A303 Sparkford to Ilchester Dualling Scheme TR010036

9.19 The Applicant's Written Submissions of Oral Case at Hearings

**The Applicant's Written Submissions of
Oral Case at Hearings**

Version	Date	Status of Version
Rev A	March 2019	Deadline 4 submission

Appendix 1 APPROPRIATE MITIGATION FOR STOPPING UP OF TERMINUS OF BRIDLEWAY Y 30/28 (EASTMEAD LANE)

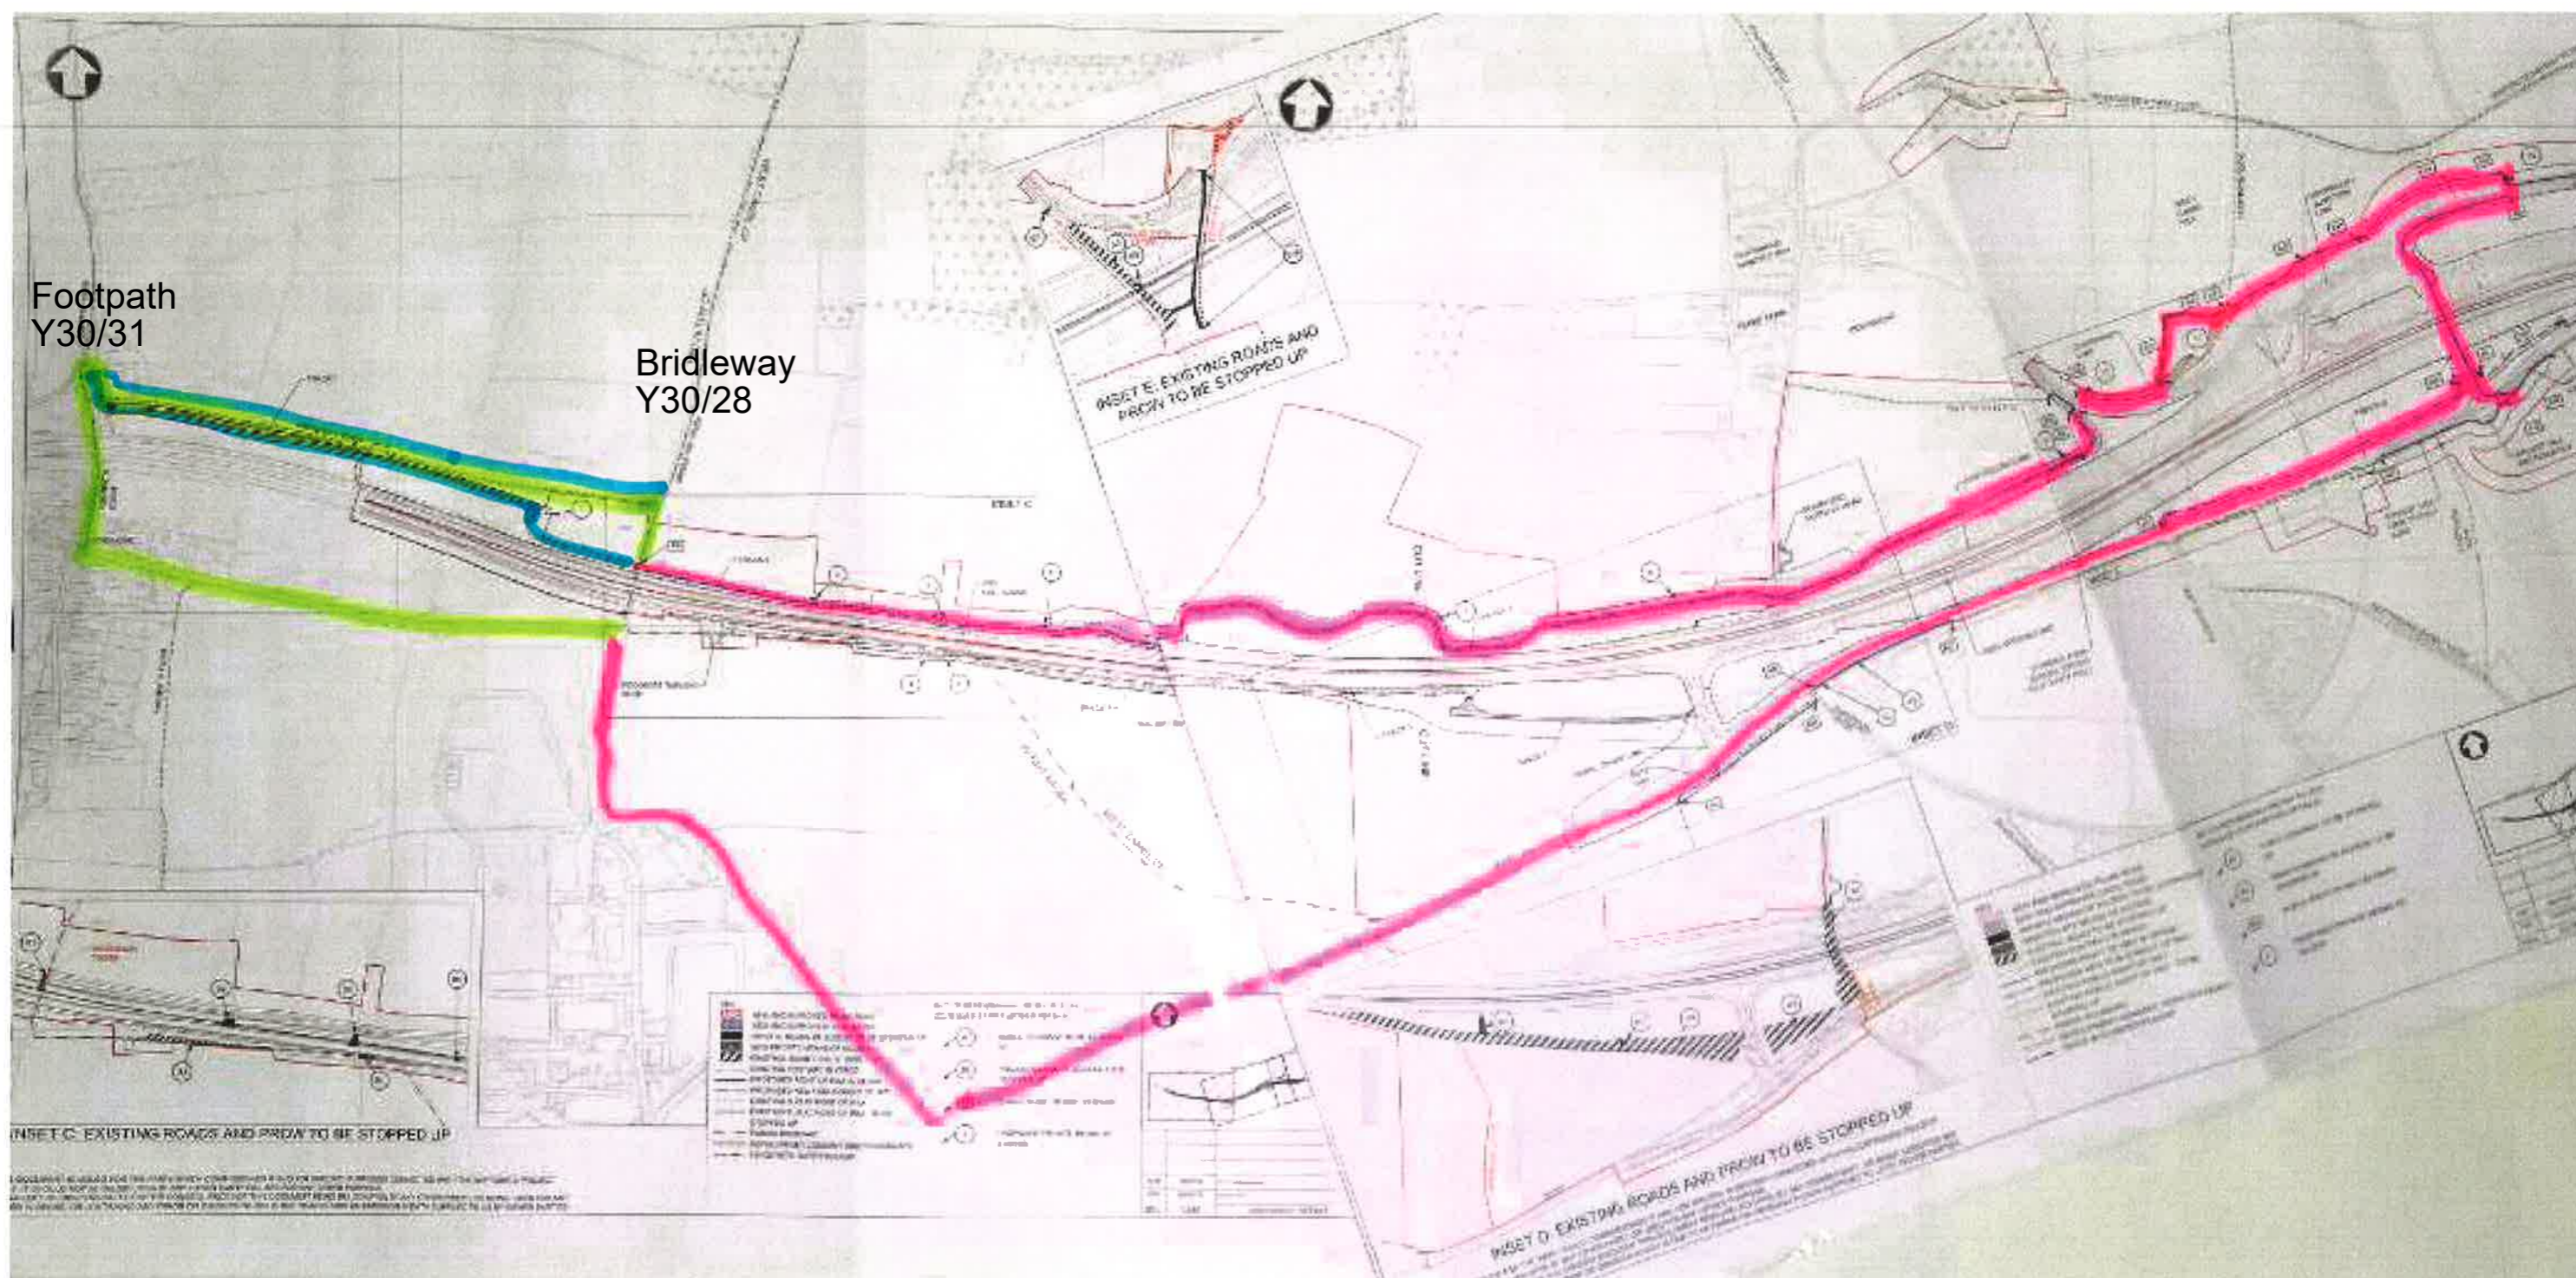
- 2.3.1 The Applicant confirmed that its position on the route sought is as set out in the submitted Topic Paper on Eastmead Lane Y30/28 (REP3-006). The Applicant's position remains that there is no Non-Motorised User (NMU) crossing of the A303 at the end of Eastmead Lane and no facilities for such. Any person crossing the A303 at this location would need to enter the cross-hatched area in the centre of the highway which should not be entered, such crossings are not safe or comfortable. Accordingly, the journey sought by the County Council is not currently possible as there is no path or way on the southern side of the A303 to cross to and therefore no route which is being cut off which would require mitigation. The comparison given of a 5.2km diversion in the Applicant's proposals to 1.5km under the County Council's proposal is not a like for like or reasonable comparison as there is no route between the points concerned at the moment to mitigate – neither route is a diversion of an existing journey.

- 2.3.2 The County Council's submission that it does not accept that a route is not possible between Eastmead Lane and Podimore was predicated on users using the A303. The Applicant does not consider that this is likely to be attractive to users given the speed of traffic on the road and the lack of off-carriageway facilities in this location and has seen no evidence of such journeys being made.
